**A1 Birtley to Coal House**  
**Scheme Number: TR010031**  
**Applicant's Response to Deadline 5**

**Applicant's Response to Deadline 5 Submissions**

<b>Version</b>	<b>Date</b>	<b>Status of Version</b>
Rev 0	19 May 2020	For Issue

Northern Gas Networks Land Ownership

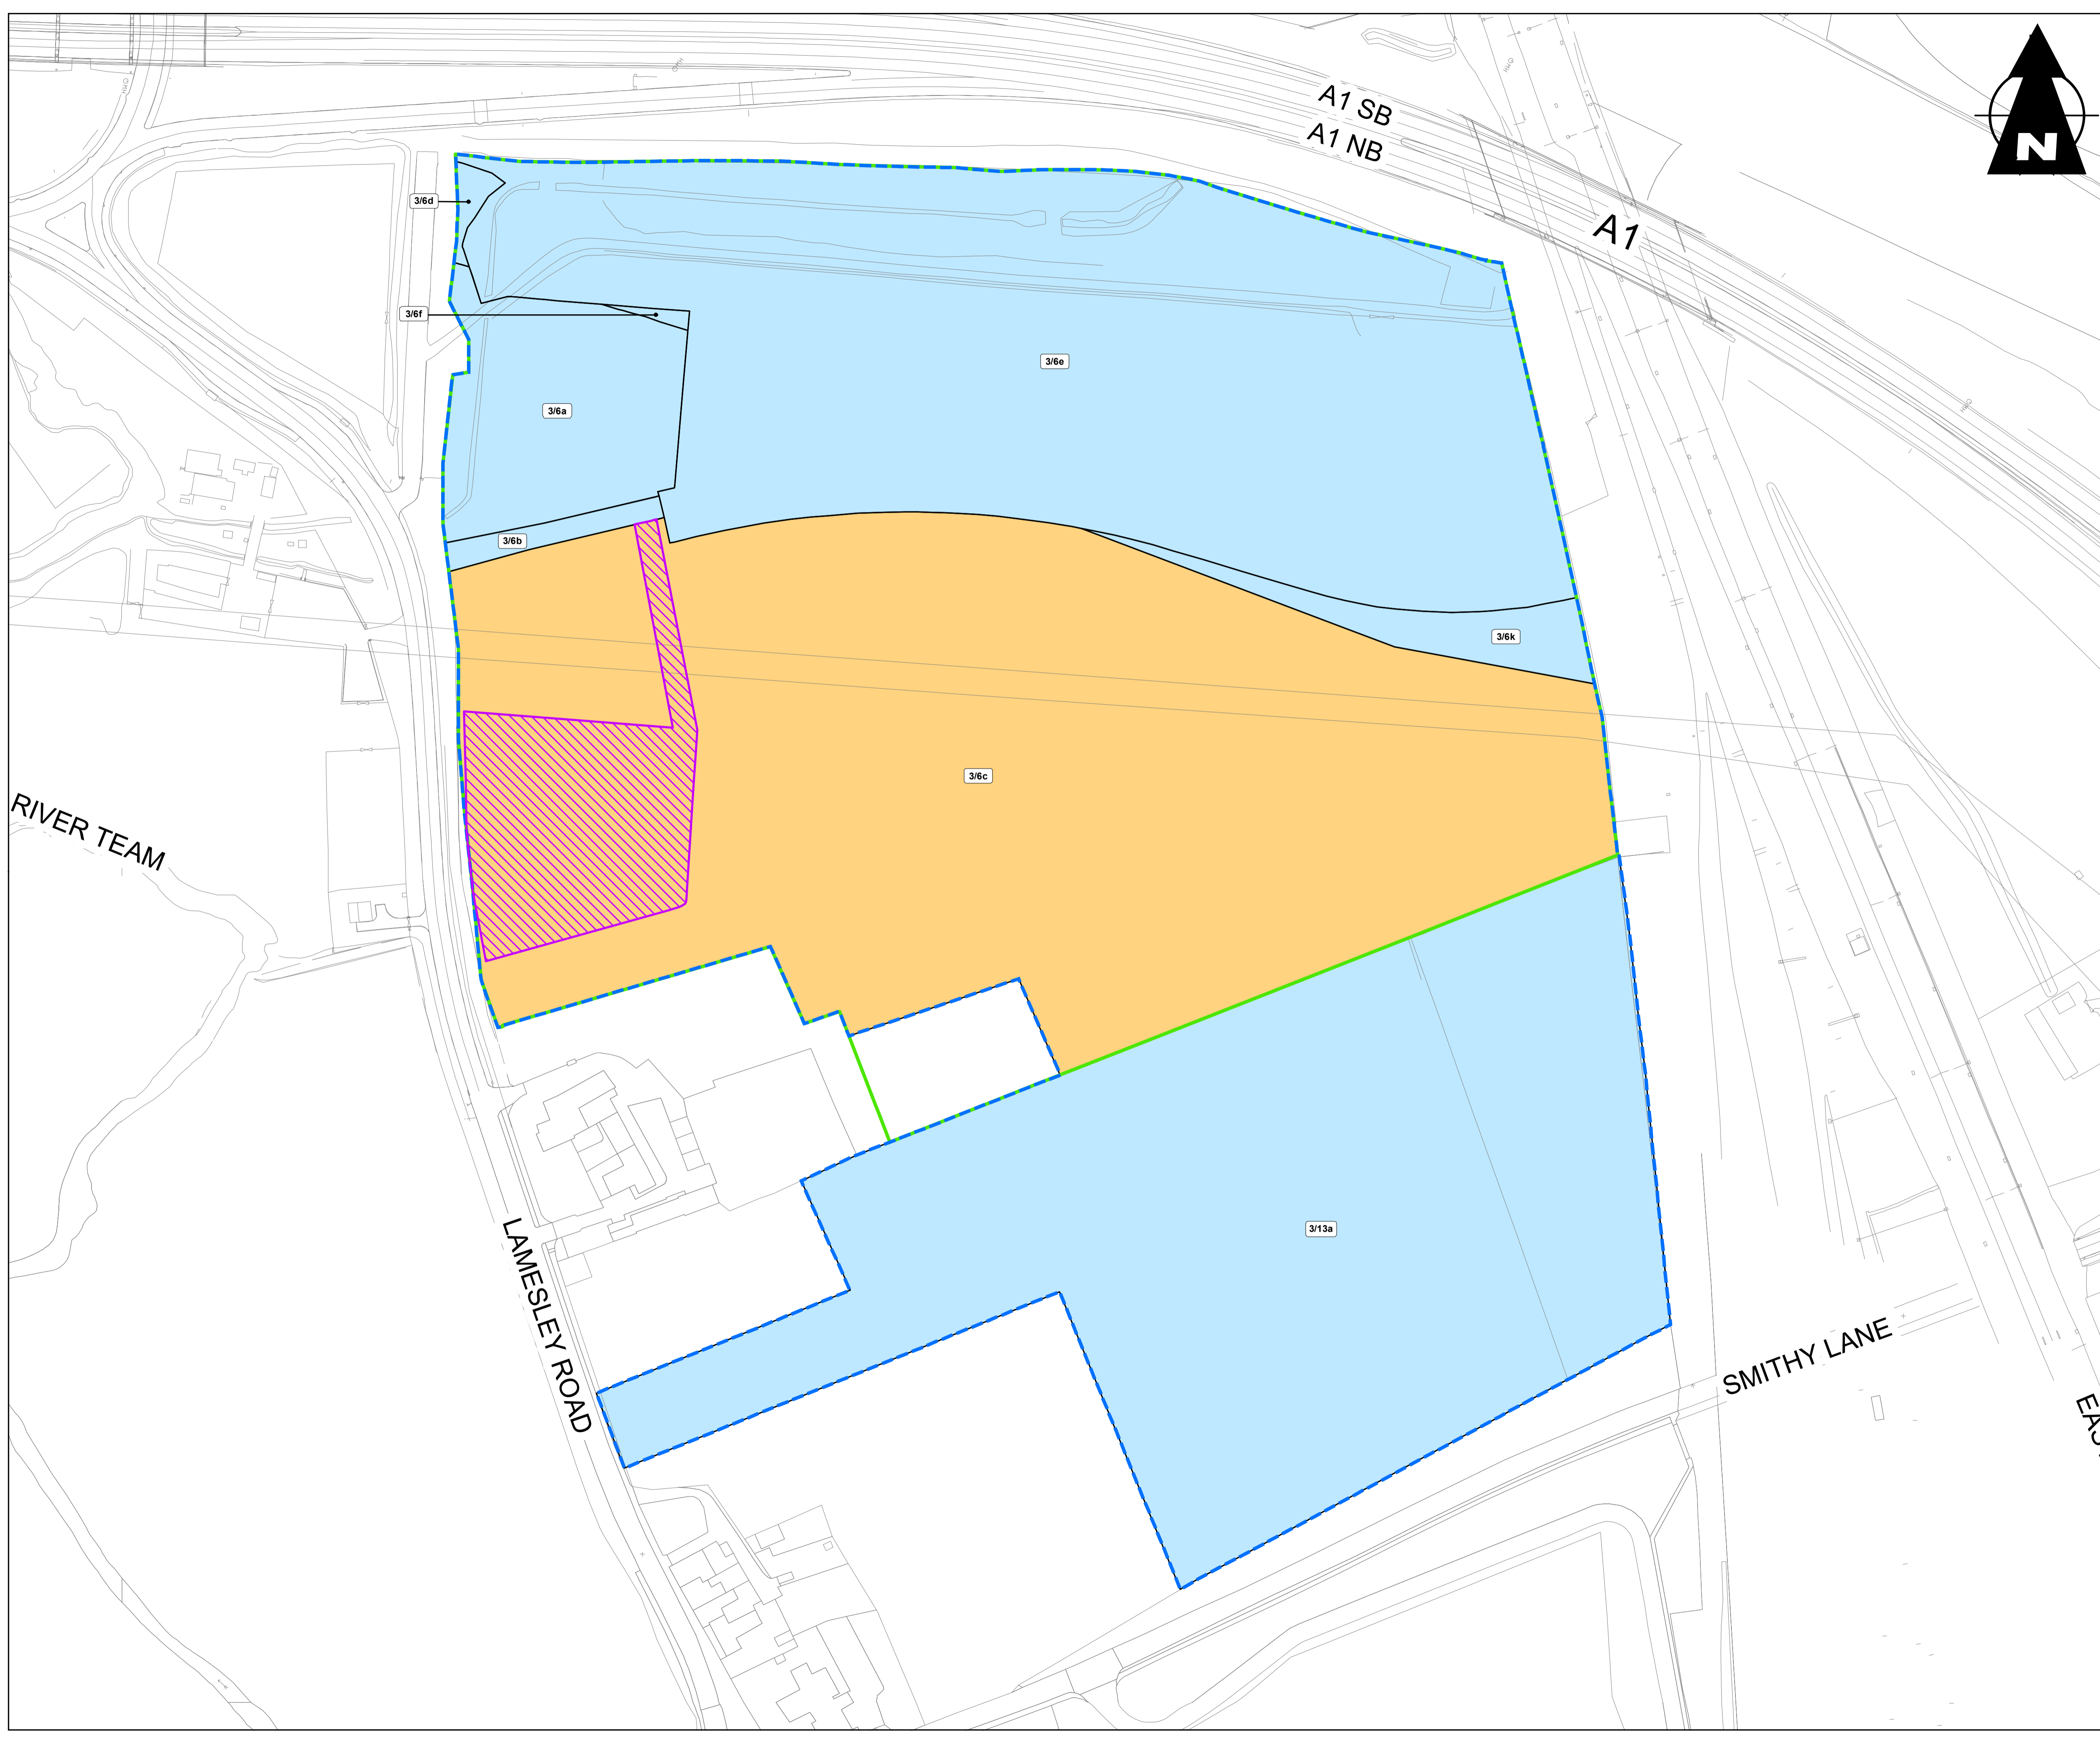
3.2	NGN does not accept that the above documents provided by the Applicant in response to Question 2.3.4 are sufficient in showing a compelling case in the public interest as to why the Applicant requires the temporary acquisition of the entirety of plot 3/6c. The Applicant's justification for acquisition of plot 3/6c only goes so far as to explain how the land may be used. At no point has the Applicant justified why the land needs to be used in this way.	<p>The Applicant does not agree that it has not sufficiently demonstrated a compelling case in the public interest for temporary acquisition of plot 3/6c. The Applicant has considered in detail the extent of land required and has assessed alternative sites [REP2-006] which were subsequently ruled out. Details of these sites has already been provided in [REP2-006].</p> <p>The Applicant has also identified the uses of the land required for the Scheme on a temporary basis in [ref]</p> <p>The Applicant does not agree that demonstrating a compelling case in the public interest test is reliant upon providing the precise layout of the working compound plot at a technical level or why the land needs to be used in a particular way. As has been stated on numerous occasions, this is far beyond what is typical for major infrastructure projects.</p>

3.3	NGN maintain that the land take is excessive, and that the Applicant is able to accommodate the CNG Filling Station within the current order limits. As shown on Figure 1, the Applicant has justified the land take by stating that a Staff Car Park will be constructed on the land that NGN seeks to retain. NGN does not accept that that there is a compelling reason as to why a car park should take precedent over the CNG Filling Station which, as previously discussed, will deliver numerous economic and environmental benefits to the area and wider transport network. This failure is even more significant given that this plot is one of the very few sites suitable for a CNG Filling Station, as previously discussed.	<p>The Applicant notes that NGN's assertion that the land take is excessive and that the CNG Filling Station can be accommodated alongside the proposed working compound is based on its review of an indicative plan of the proposed layout of the working compound only. However, this is based on assertion only. It is not based on any evidence that NGN has obtained or that the Applicant has provided.</p> <p>The Applicant reiterates its position in respect of the planning merits of constructing a CNG Filling Station in the green belt and considers that NGN has failed to demonstrate that the economic and environmental benefits that it refers to are achievable within the period of temporary possession of the plot. NGN has provided no evidence that this site is one of the few sites capable of accommodating a CNG Filling Station and has already stated that it has not yet undertaken any viability study for whether the CNG Filling Station is appropriate in this location.</p> <p>The car park is required to provide the necessary facility to accommodate the services to support the construction of the scheme. This facility will enable safe and secure access on and off site for staff delivering services to enable construction and access for contractor to undertake construction work.</p>

Ref:	Northern Gas Networks Limited Response:	Applicant's Comment:
3.4	<p>NGN also does not accept that the site layout provided in Figure 1 of the updated CEMP provides an accurate representation of the construction compound. As has previously been submitted, there are overhead lines running across the site which, by their nature, will impact the works able to be carried out on the land underneath. We do not believe that Plant, Material and Subcontract stores will be workable in this area, as the height of the overhead lines will restrict movement and the ability for vehicles to be able to pass safely underneath and within the exclusion zone of the lines.</p>	<p>The site layout provided has been prepared by expert consulting engineers and is based upon best practice and industry standards for a compound that will be required to support a scheme of this nature, duration and size. With regard to the overhead line, it is at a sufficient level above ground such that mitigation can and will be put in place for safe movement and operation of vehicles and plant beneath. This is demonstrated by the fact that the overhead cables run across Lamesley Road adjacent to the site, which is clearly used extensively by normal and heavy vehicular traffic. It must be noted that the plant, material and sub contract storage areas are bounded on all sides by the one way compound access route and as such the areas may be accessed from either the north or the south, minimising the need for plant and vehicles to cross beneath the overhead line.</p> <p>Insofar as activity is required which may not take place beneath an overhead line, this can be accommodated in other parts of the proposed site area.</p>

3.5	<p>NGN is therefore not in a position to accept the Applicant's justification of the temporary acquisition of Plot 3/6c and invites the Applicant to provide a workable construction compound layout, including a justification presenting a compelling case in the public interest for acquiring the land, in light of the proposed CNG Filling Station. If the Applicant is unable to do this, there is no legal or policy basis for the compulsory acquisition of plot 3/6c.</p>	<p>The Applicant disagrees with NGN's interpretation of the evidence that has been provided to date and the characterization of the Applicant's case. The Applicant has made a case for the need to use the land in question, which is supported by expert and factual evidence. There is a strong legal and policy basis for the grant of powers over the land in question.</p> <p>It is not necessary or appropriate at this stage in an application to present a particular construction compound layout.</p>
